From: Hornby, Mark [Mark.Hornby@lancashire.gov.uk]
Sent: 18 October 2011 15:49
To: Graeme Thorpe
Cc: Nugent, Martin; ENV EPP Customer Service Area East
Subject: FW: Consultation on planning application 3/2011/0482 Brown Leaves Country Hotel, Longsight Road, Copster Green

This proposal has been the subject of discussions between the applicant and my colleague Mr Nugent prior to the planning application being submitted. We have no objection in principle to the application on highway safety grounds, subject to the following conditions:

Drawing:
Junction Layout

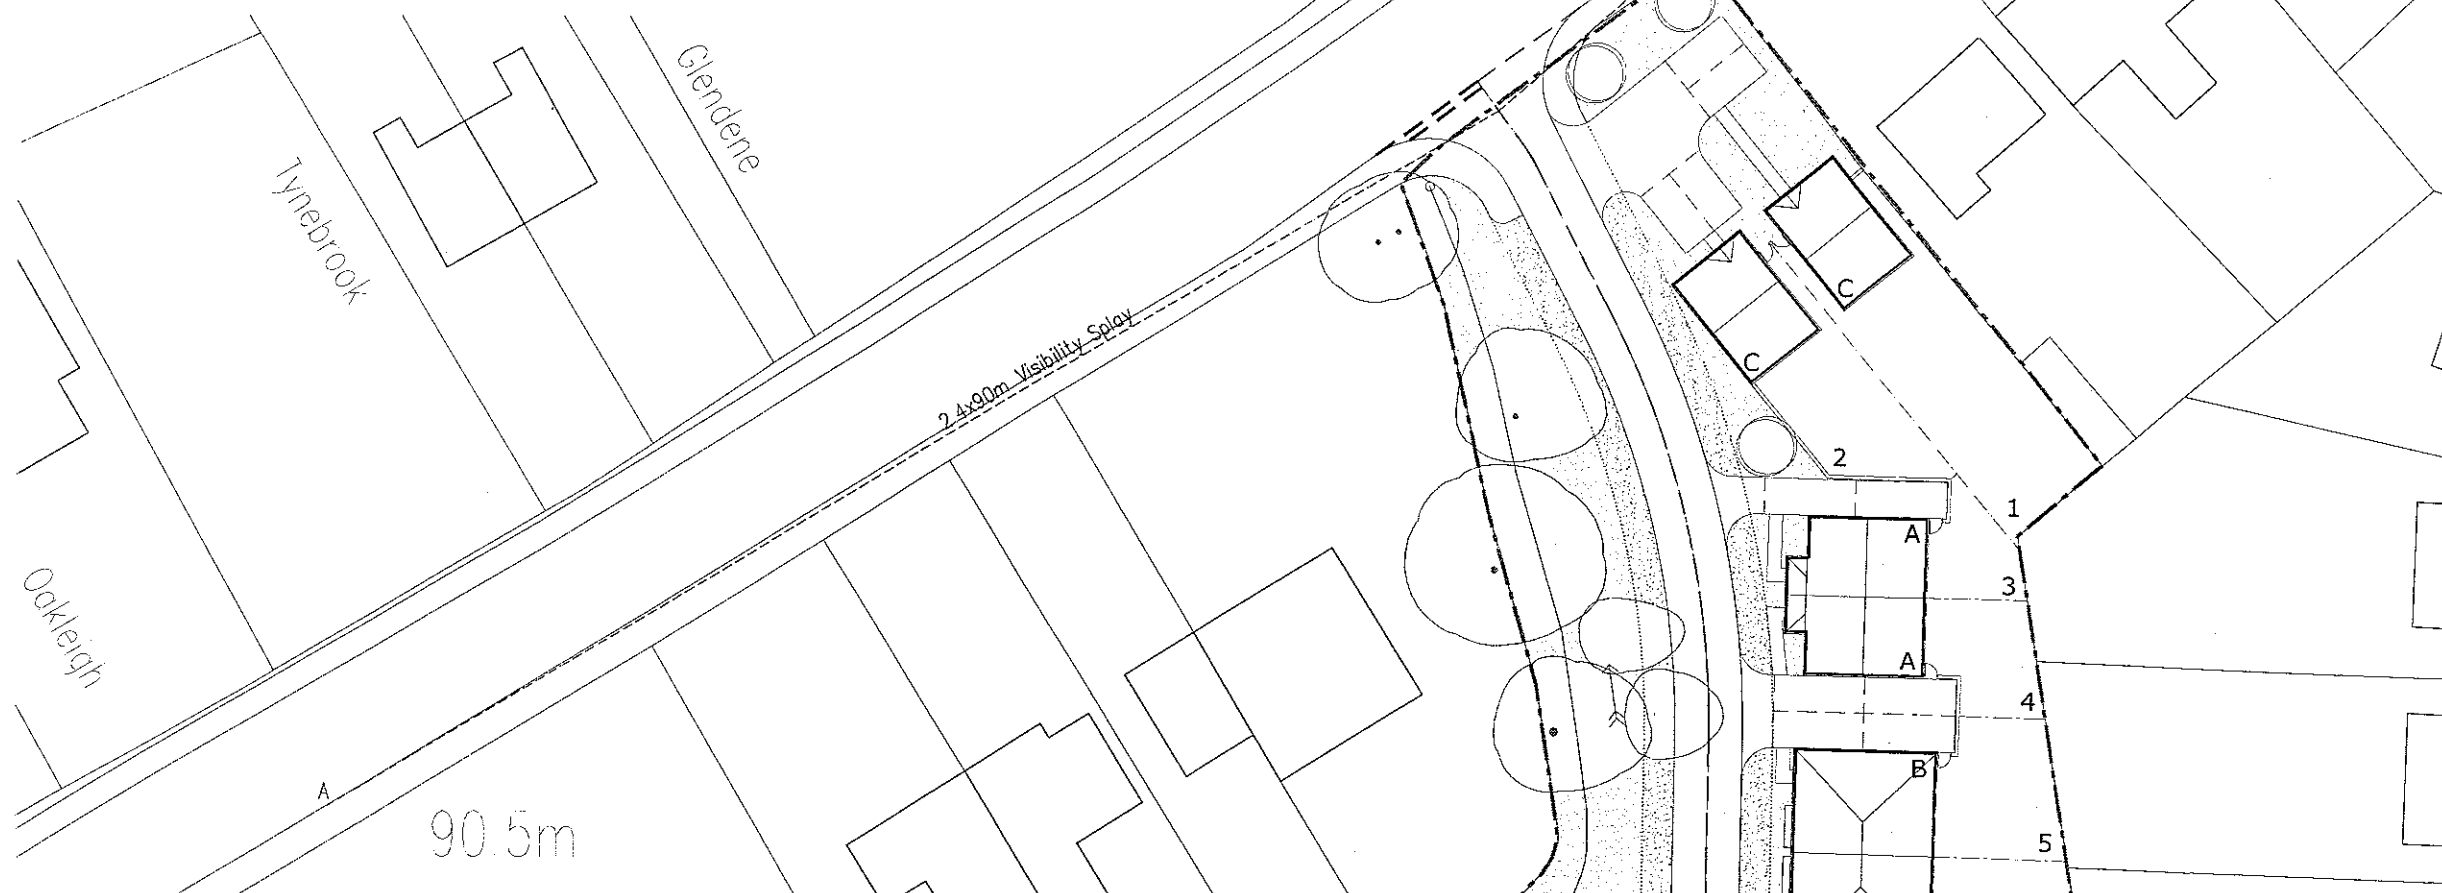
1. There shall not at any time in connection with the development be erected or planted or allowed to remain upon the land hereinafter defined any building, wall, fence, hedge, tree, shrub or other device. The visibility splay to be the subject of this condition shall be that land in front of a line drawn from a point 2.4 metres measured along the centreline of the proposed access road from the nearer edge of the carriageway of the A59 Longsight Road to points measured 90 metres in each direction along the nearer edge of the carriageway of the A59 Longsight Road, and shall be constructed and maintained at footway level in accordance with a scheme to be agreed by the Local Planning Authority in conjunction with the Highway Authority. Reason: To ensure adequate visibility at the site access.

2. The existing Clayton-le-Dale boundary sign adjacent to the proposed access road shall be removed and relocated to a suitable alternative position at the developers expense. Reason: To ensure adequate visibility at the site access.

3. The proposed access road from the site to the A59 Longsight Road shall be constructed to a width of 5.5 metres and this width shall be maintained for a minimum distance of 10 metres measured back from the nearside edge of the carriageway of the A59 Longsight Road. Reason: To enable vehicles to enter and leave the site in a safe manner without causing a hazard to other road users.

4. The new estate road/access between the site and the A59 Longsight Road shall be constructed in accordance with the Lancashire County Council Specification for Construction of Estate Roads to at least base course level before any development takes place within the site. Reason: To ensure that satisfactory access is provided to the site.
